SCHEDULE OF CHANGES TO DEVELOPMENT CONSENT ORDER

Drax Bioenergy with Carbon Capture and Storage

Document Reference Number: 3.1.3

DATE: April 2023

DRAWING TITLE
 CROWN LAND PLAN

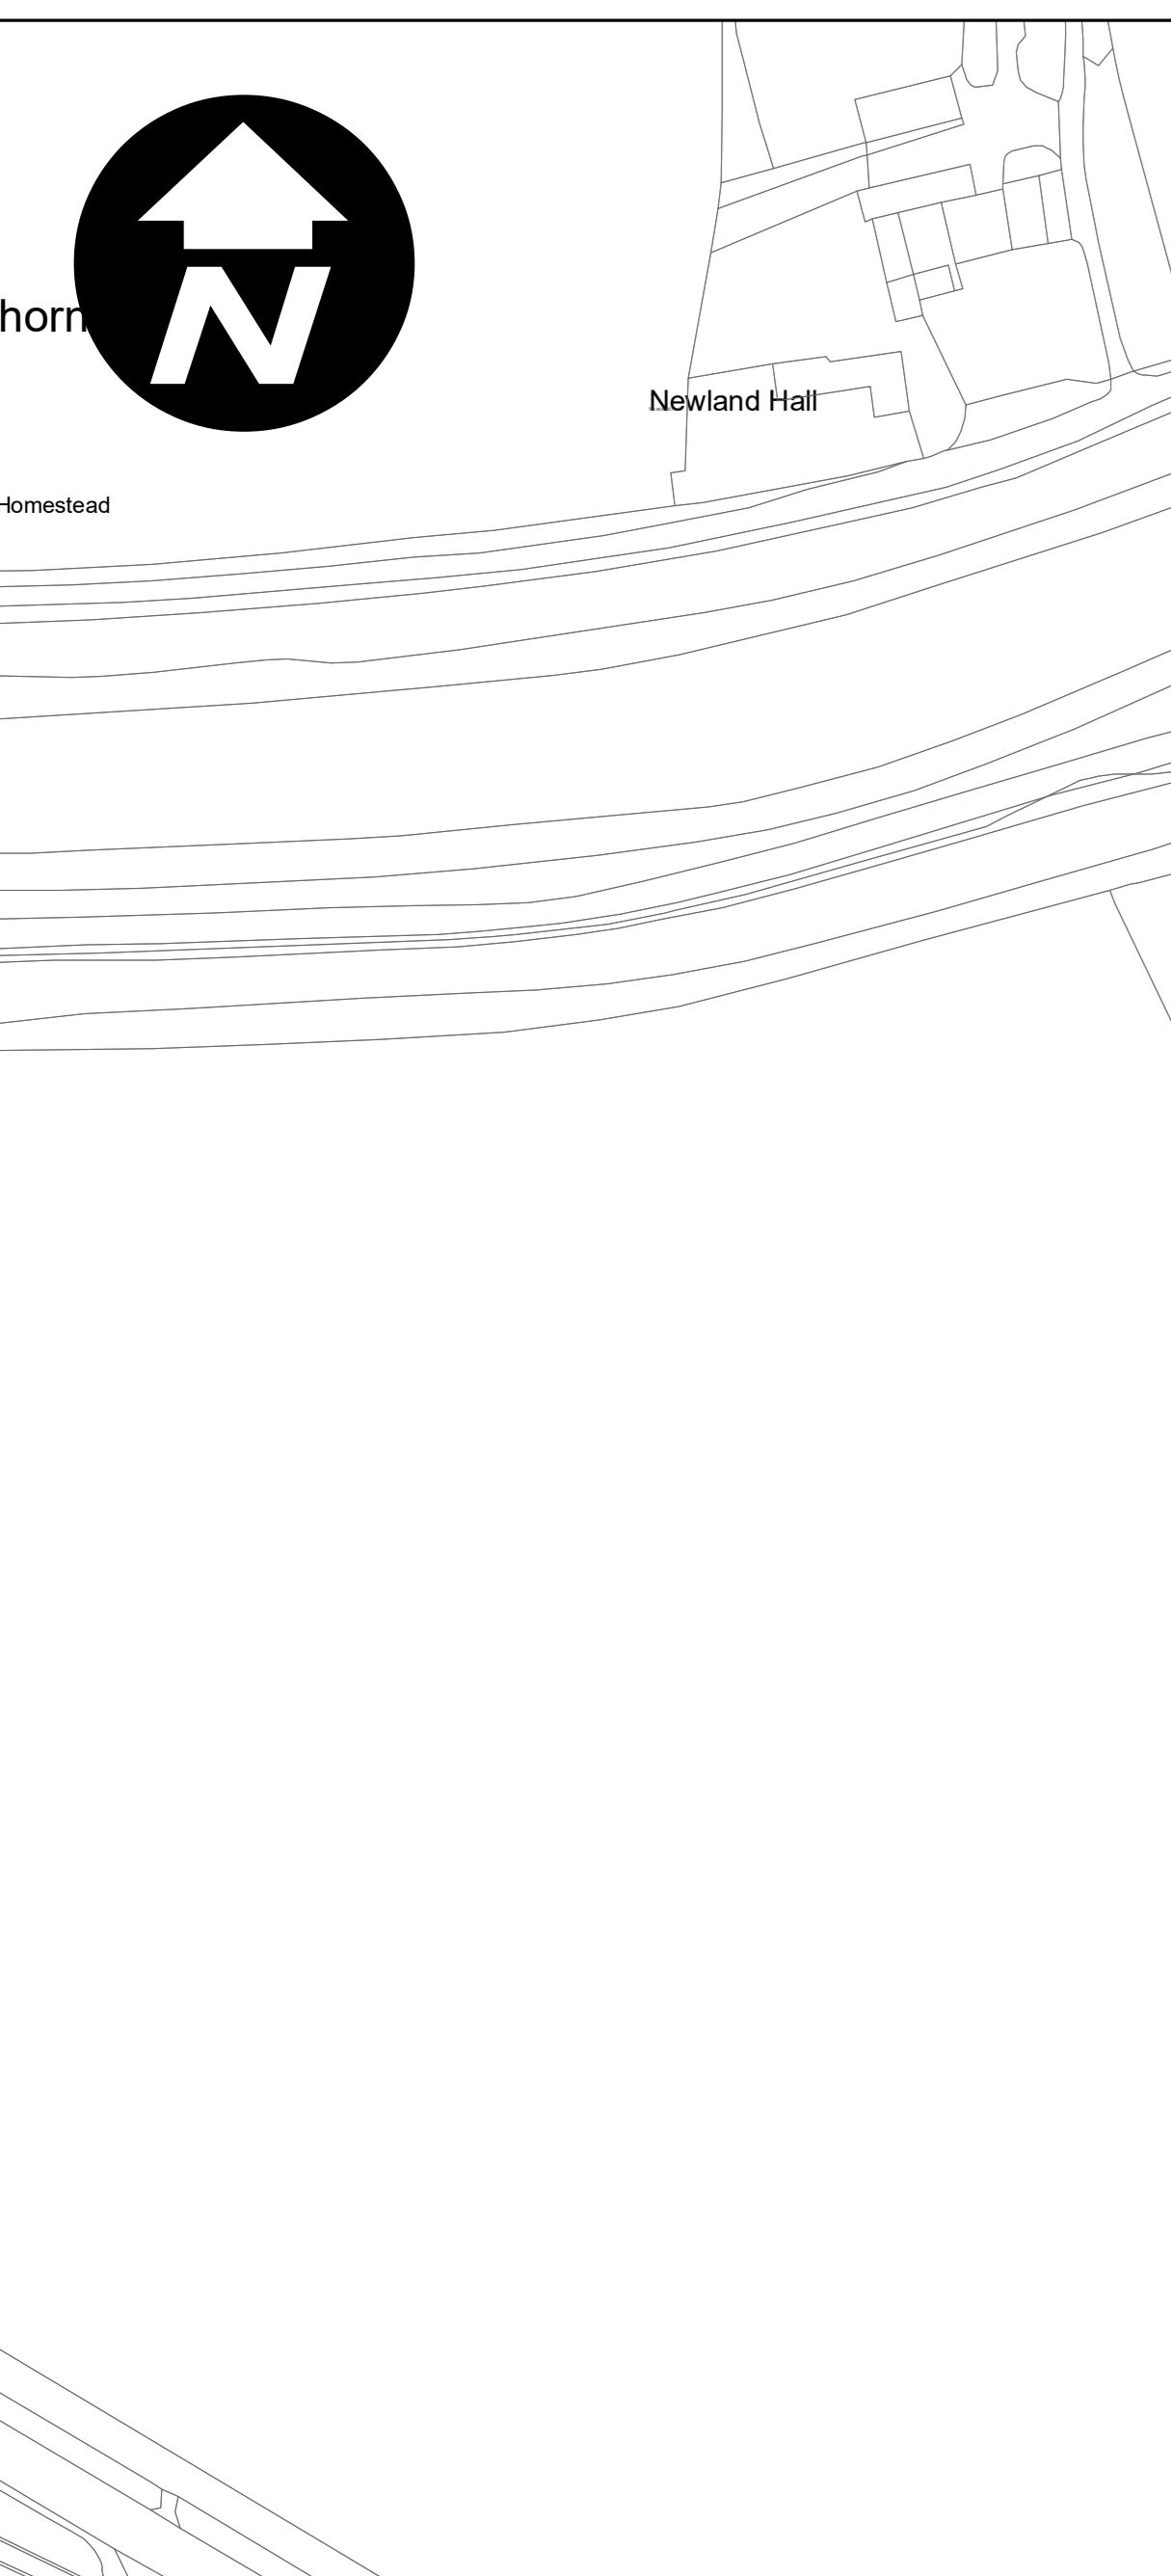
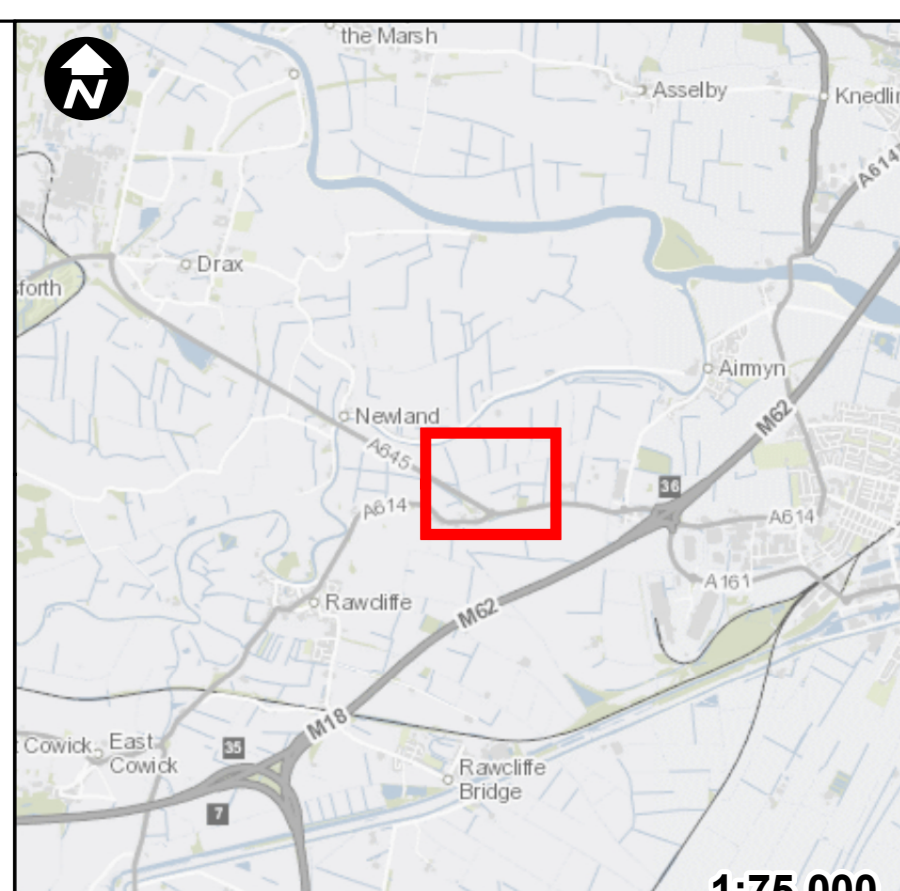
Reference	Change	Reason for Change
Article 2 (Interpretation)	Addition of definition of “crown land plan”.	Crown Land drafting restored following discussions at Compulsory Acquisition Hearing and on-going correspondence with Department for Transport.
Article 8(4) (Application and modification of statutory provisions)	Addition of sub-paragraph 4; <u>(4) The carrying out of Work No. 8A shall not be regarded as conflicting with, or constituting non-compliance by, any person of any conditions of a planning permission granted under section 57(f) (requirement of planning permission) of the 1990 Act which relate to plots 01-108, 01-110 and 01-115 of the land plans or land adjacent to those plots outside of the Order limits.</u>	Crown Land drafting restored following discussions at Compulsory Acquisition Hearing and on-going correspondence with Department for Transport
Article 20(7) (Compulsory acquisition of rights)	Addition of sub-paragraph 7; <u>(7) This article is subject to article 44 (Crown rights).</u>	Crown Land drafting restored following discussions at Compulsory Acquisition Hearing and on-going correspondence with Department for Transport.

Reference	Change	Reason for Change
Article 44 (Crown rights)	Addition of Crown rights article.	Crown Land drafting restored following discussions at Compulsory Acquisition Hearing and on-going correspondence with Department for Transport.
Schedule 1	Various amends to Work No.8A and Work No.8B.	To account for the changes to works methodology as a result of the SCA.
Schedules 4, 5 and 7	Various amends made to specific works to streets and accesses required.	Amendments made to reflect changes to Access and Rights of Way Plans, which reflect changes to works methodology as a result of the SCA.
Schedule 8, Part 1 and Part 2	Various amends to plot numbers and purposes throughout Schedule 8.	Changes made to land powers required for plots as a result of the SCA and explained in the Statement of Reasons Addendum submitted with the SCA.
Schedule 10	Amends to plot numbers and purposes throughout Schedule 10.
